Site Plan Map Revision 6

Date: 2023-Nov-30

Parcel #: 4122000002

Location: 16888 Elbert Road, Peyton, CO 80831

Site Plan

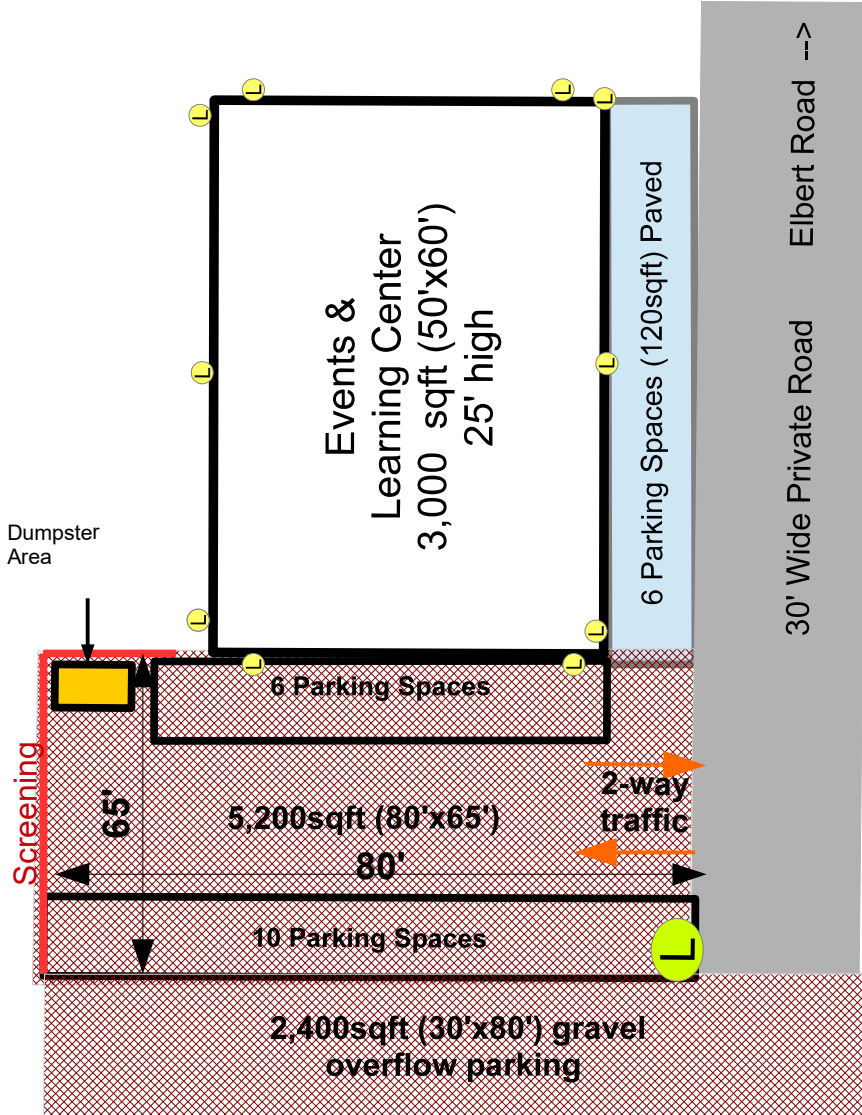
Unresolved V2 comments:

Please include:

- Right of way dedication
- dimensions of parking, paved?
- Code states for rural parking 25 or more = paving required
- please include a parking table going over use, required vs provided
- Adult care home = 1 / 3 beds
- B&B= 1 / 2 rooms
- Commercial center = 1 / 300 sq ft
